VICTORIA EMBANKMENT FORESHORE AND BLACKFRIARS BRIDGE FORESHORE APPLICATION STATEMENT

**To support a proposed non-material amendment
to the Thames Water Utilities (Thames Tideway
Tunnel) Order 2014 (as amended)**

Name	Data
Document ref:	2530-TDWAY-TTTUN-990-ZZ-RG-704430
Legacy document ID:	
Document type:	Report
WBS Code:	n/a
Owner:	Roger Bailey
Author:	Liz Wood-Griffiths
Keywords:

Drawing file: WW010001 / WW010001-006138-DCO-PP-16X-VCTEF-180008_Rev4_A3__Authorised.pdf

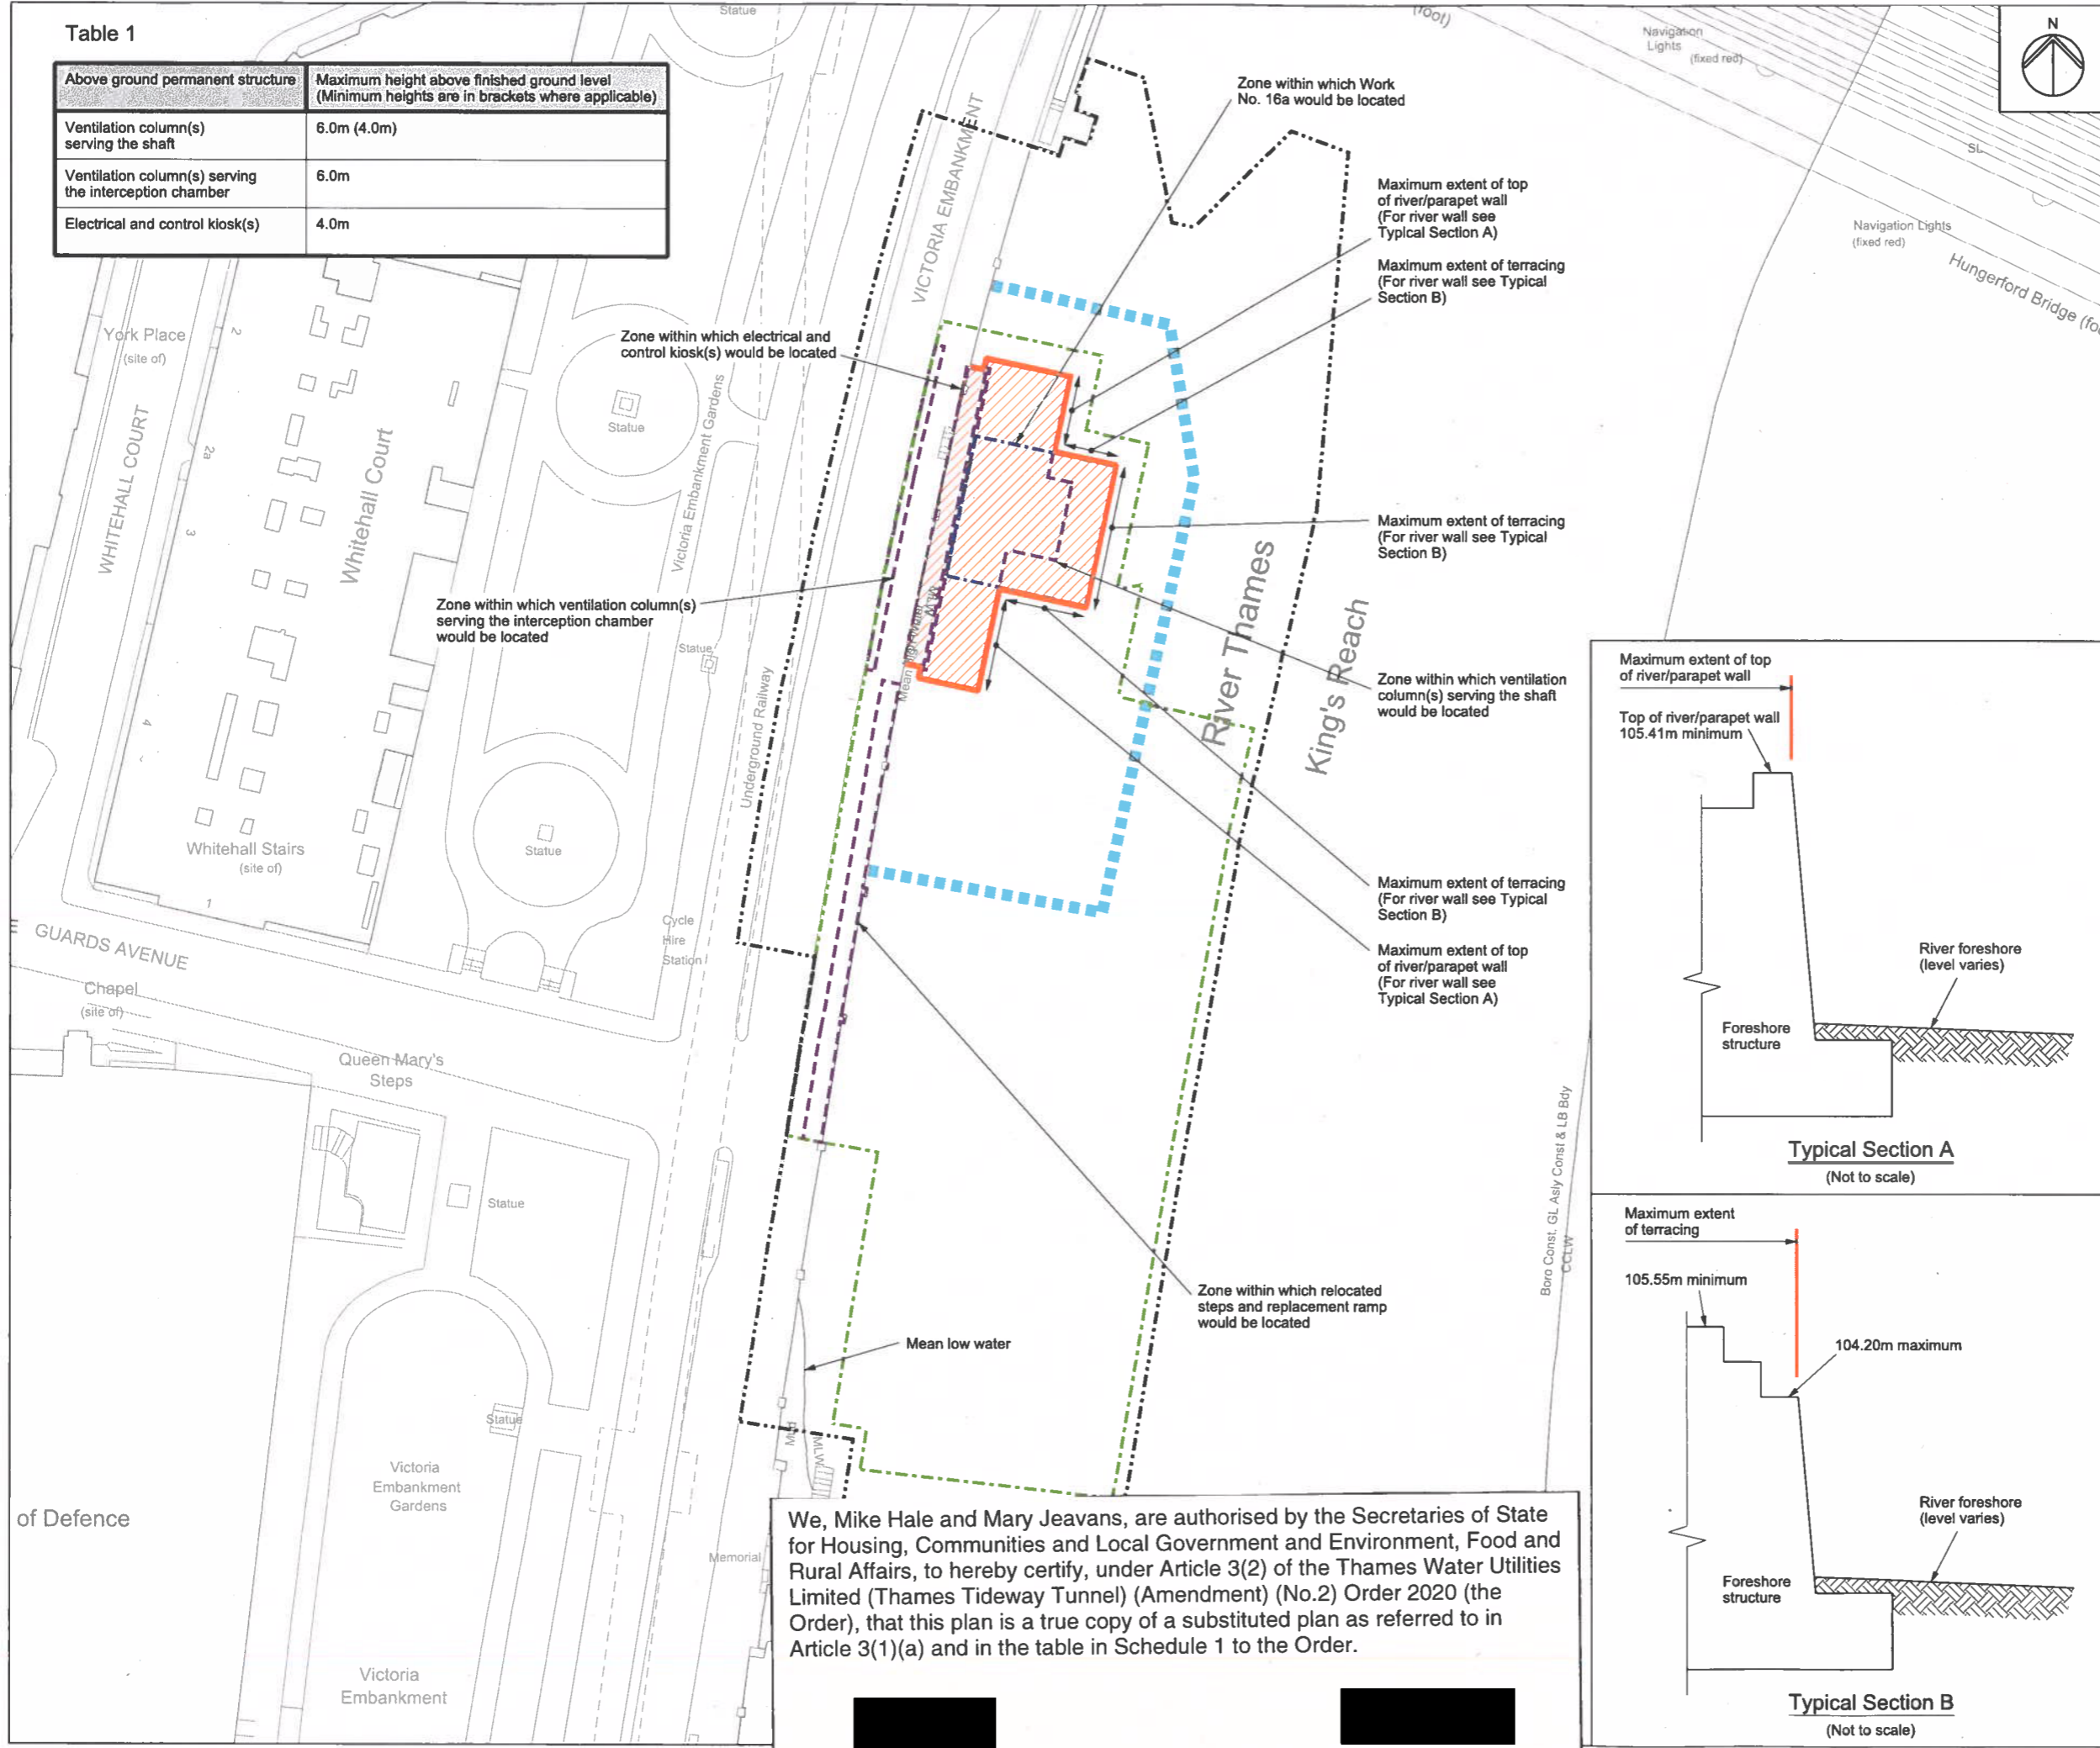
- 2.2.3 The amendment proposed to the Site works parameter plan at VCTEF (Drawing DCO-PP-16X-VCTEF-180008-rev 3) would amend the “blue zone” (shaft) parameter. Note 3 on the approved plan states: *“The zone within which the shaft would be located would include all permanent works including shaft walls (including appropriate allowances for construction tolerances) and if applicable under-reaming. Shaft construction temporary works may be located within or outside this zone provided they are located within the Limits of land to be acquired or used.”* The illustrative permanent works layout plan (drawing DCO-PP-16X-VCTEF-180010-rev2) shows the proposed location for the shaft and its location within the blue shaft parameter zone. It is apparent from this drawing that the shaft as proposed at the time of the DCO application, could not be constructed within the shaft parameter shown on the approved Site works parameter plan as the shaft walls on the landside (western boundary) are shown extending beyond the approved zone for construction.

- 2.2.4 Note 3 on the approved drawing makes it clear that all permanent works associated with the shaft including shaft walls and under-reaming should be located within the shaft parameter. At this site an ‘under-ream’ (approximately 50m below ground level) is required at the base of the shaft for the shaft to resist flotation. Additionally, a structural ring beam is required in the top 7m of the shaft to protect the integrity of the shaft in the event of an accidental ship impact event. As currently drawn, the under-ream at the base of the shaft and local thickening of the walls in the top 7m of the shaft would fall outside the western boundary of the shaft parameter zone.

- 2.2.5 The proposed amendment to the Site works parameter plan would modify the western boundary of the shaft parameter zone and extend it to the west so that the under-ream and shaft walls will be within the shaft parameter zone to comply with note 3 on the drawing. The amended shaft zone would remain within the green zone within which all permanent site structures are to be located. The need for the amendment to the Site works parameter plan at this site is required to correct an anomaly on the approved plan which prevents the works from being constructed as originally intended. There are no changes to the size or location of the shaft at VCTEF.
